**State significant development application – SSD7684 - Staged redevelopment of Cockle Bay Wharf
241 – 249 Wheat Road, Cockle Bay Darling Harbour**

Roads and Maritime Services (Roads and Maritime) refers to development application number SSD7684 (the **DA**) lodged by JBA Urban Planning Consultants Pty Ltd on behalf of DPT Operator Pty Ltd and DPPT Operator Pty Ltd (**Proponent**) for a staged development.

The purpose of this letter is to provide comments from Roads and Maritime in respect of the Project.

**Principles of Construction Traffic Management**  
**- Wheat Road Diversion Works**

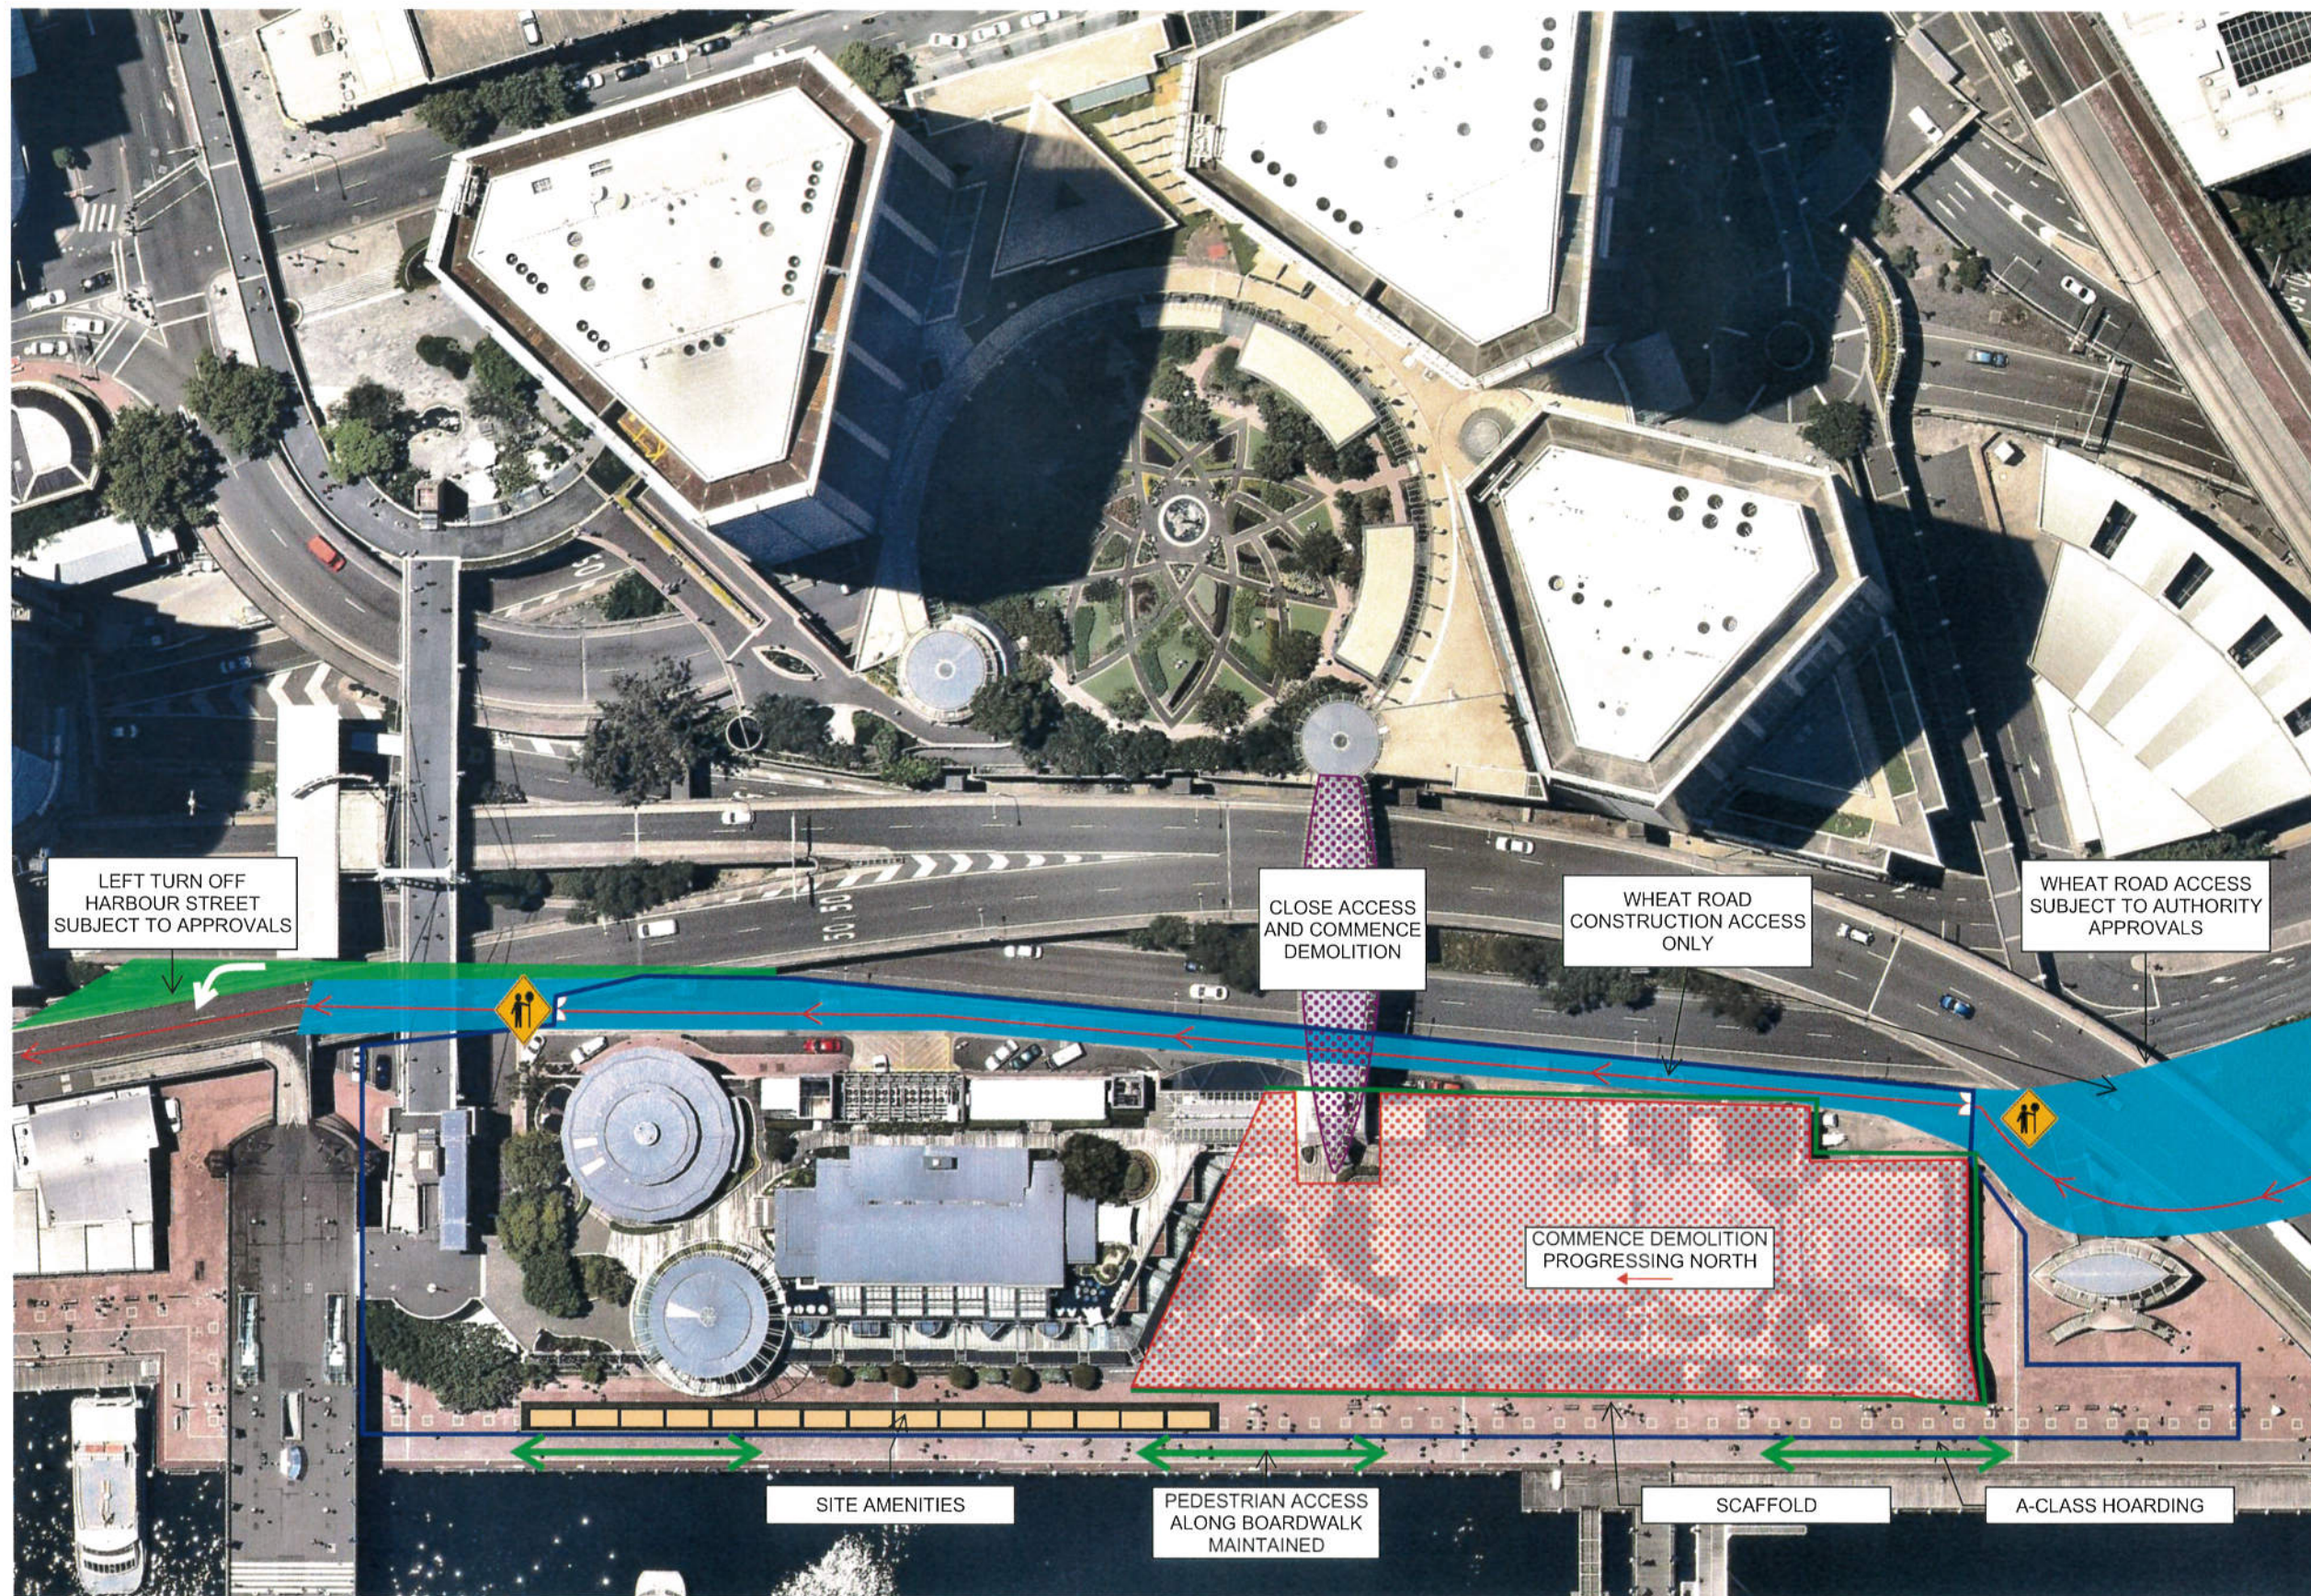
- f) **Wheat Road** – the proponent will need to provide further details of the arrangements to be made around the Site, particularly around Wheat Road, to enable safe and efficient vehicular access to the Project without unreasonably interfering with existing traffic flows. Roads and Maritime notes that there is currently an approved development for the IMAX Theatre which contemplates potential changes to these roads. Any proposed changes in this development application need to be consistent with any changes approved as part of the IMAX Theatre redevelopment (SSD 7388). The proponent will need to ensure that access, including emergency access, is maintained at all times to the Cross City Tunnel assets including in and around the ventilation stack, to the satisfaction of Roads and Maritime and the Cross City Tunnel operators. In this regard, the Project contemplates the modification of the Harbour Street/Wheat Road and Blackwattle Place intersection to allow left and right turn movements on to Harbour Street, however, the modifications contemplated by the Project would unreasonably compromise through traffic movements in this area and the traffic volumes contemplated by the Project do not warrant traffic control lights. The proposed intersection arrangement should be investigated from a road safety perspective and details of how taxi, pedestrian and vehicle movements will be affected under the proposed modifications and how the changes should be maintained should be considered.
